RE: **Montgomery Carwash**
3525 Montgomery NE
Grading Plan Stamp Date: 4/1/19
Hydrology File: F16D053

Based on the submittal received on 4/2/19, the Grading and Drainage Plan cannot be approved until the following are corrected:

RE: **Montgomery Carwash**
3525 Montgomery NE
Grading Plan Stamp Date: 10/31/18
Hydrology File: F16D053

Based on the submittal received on 11/1/18, the Grading and Drainage Plan cannot be approved until the following are corrected:

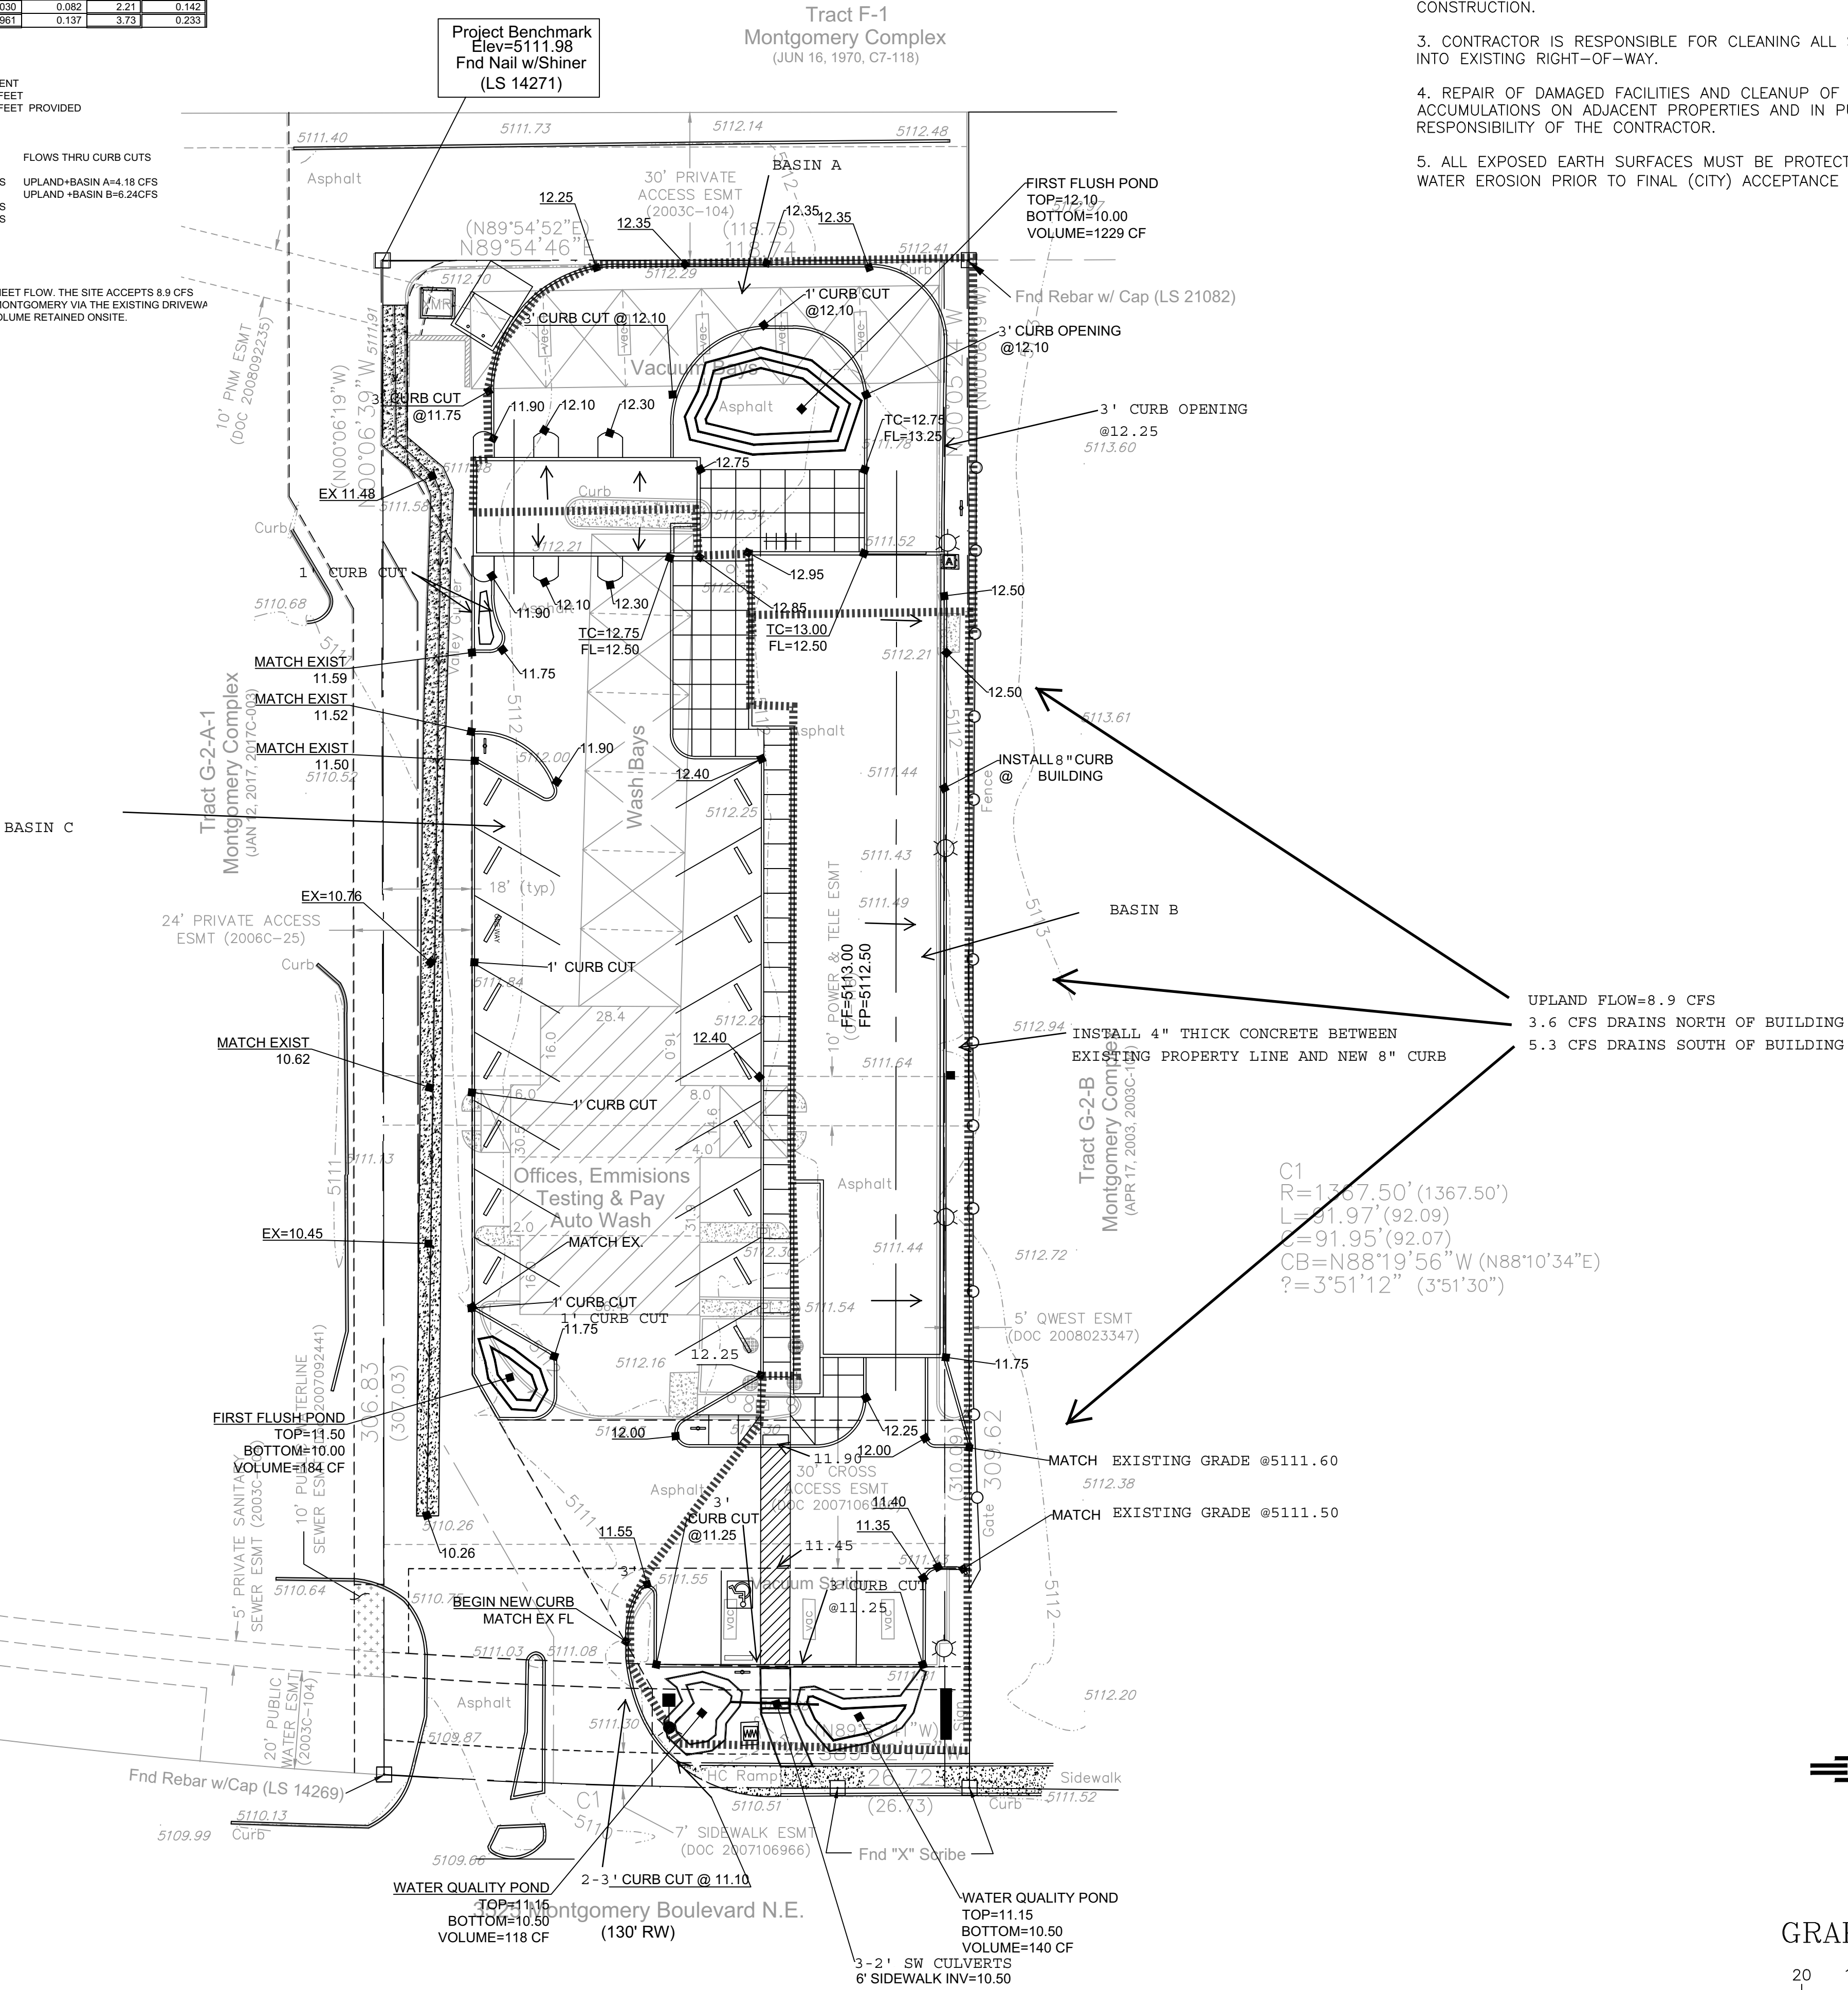
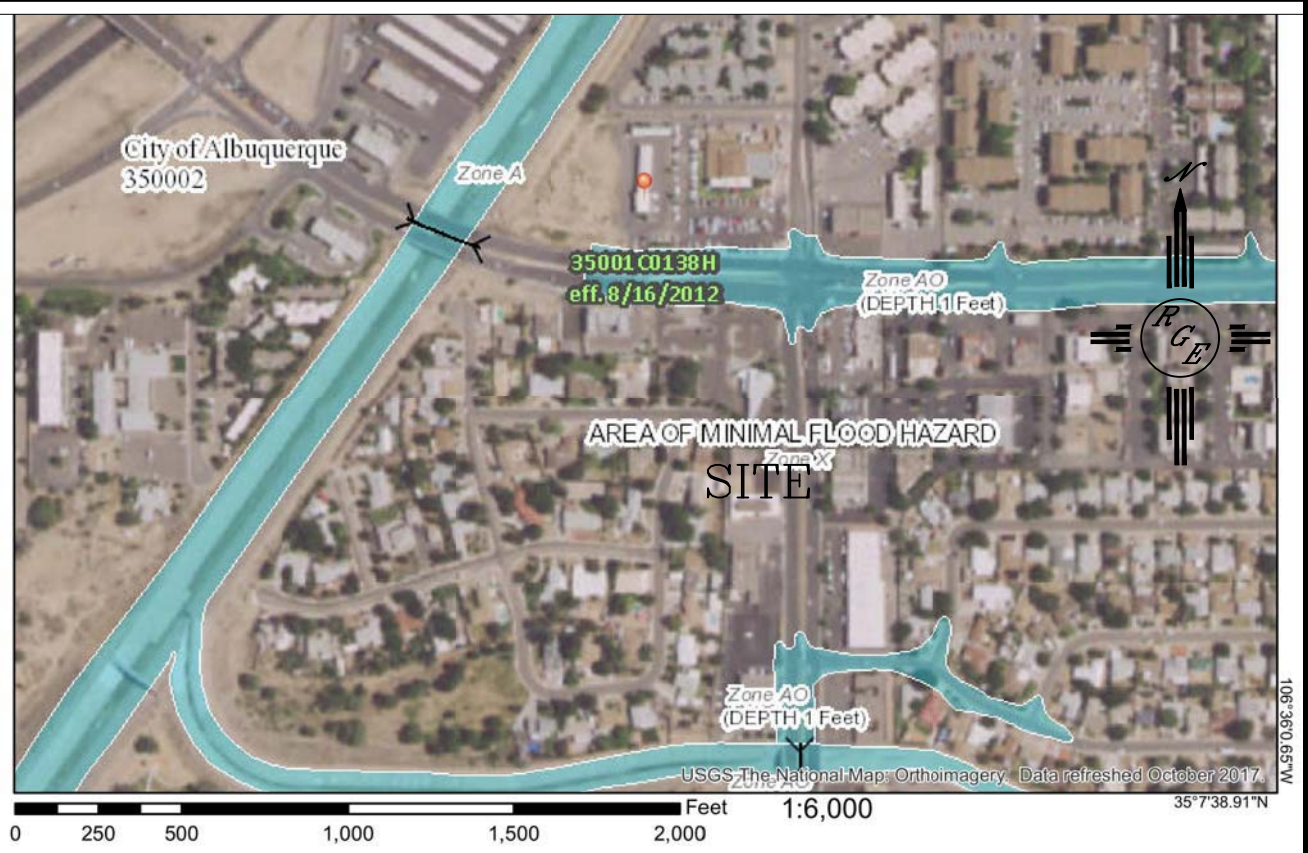
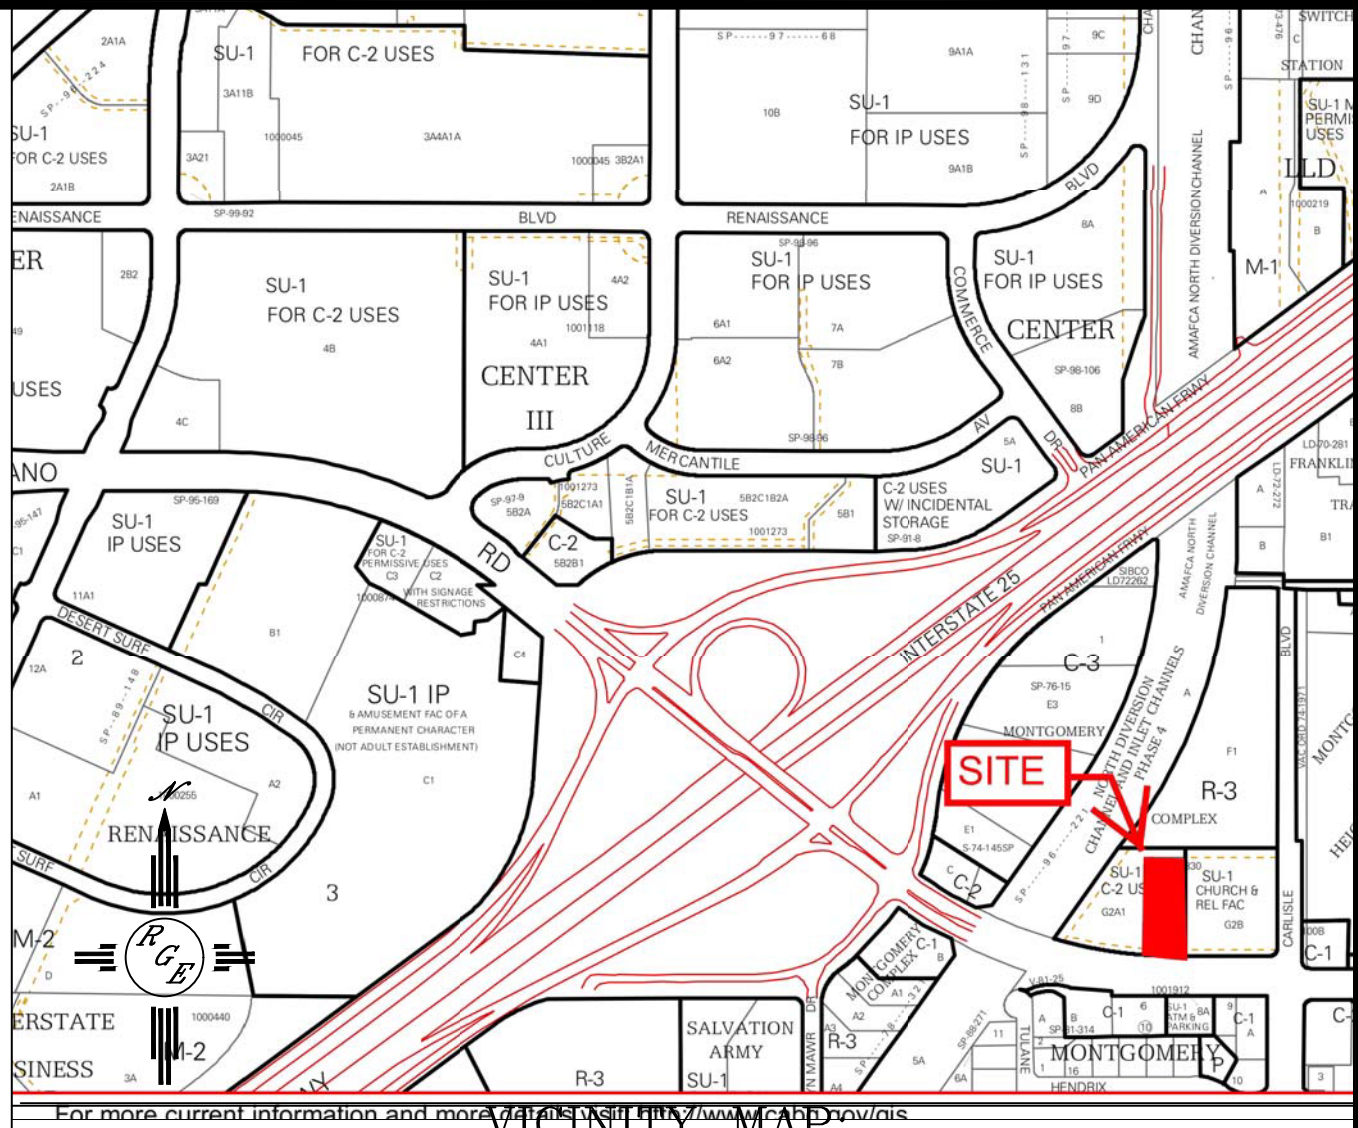
1. Basin C delineation needs to be shown on the plan. It is unclear how any of Basin C makes it to a stormwater quality pond.

2. Provide management onsite for the entire Stormwater Quality Volume in accordance with the new drainage ordinance, § 14-5-2-6 (H) enacted 10/2/18 (Council Bill C/S O-18-2). This site qualifies as redevelopment and is only required to manage runoff from the 80th percentile storm (Vol. = 0.26''*Imp.Area).

3. Each stormwater quality pond need to be sized for the area draining to it. These areas need to be clearly delineated and shown on the plan, or as a separate exhibit.

4. Provide a section through the building and east property line. How will the channel manage the roof runoff and the offsite flows? Please show the channel in plan view.

WE HAVE PROVIDED BASIN AND POND SUBBASINS ON PLAN

WE HAVE UPDATED. A FEE IN LIEU WILL BE PAID

THE UNTREATED PORTIONS OF EACH BASIN HAS BEEN CALCULATED

WE HAVE PROVIDED SUBBASIN BOUNDARIES AND INCLUDED IN CALCULATIONS

SECTION AND PLAN VIEW HATCHING OF CHANNEL PROVIDED
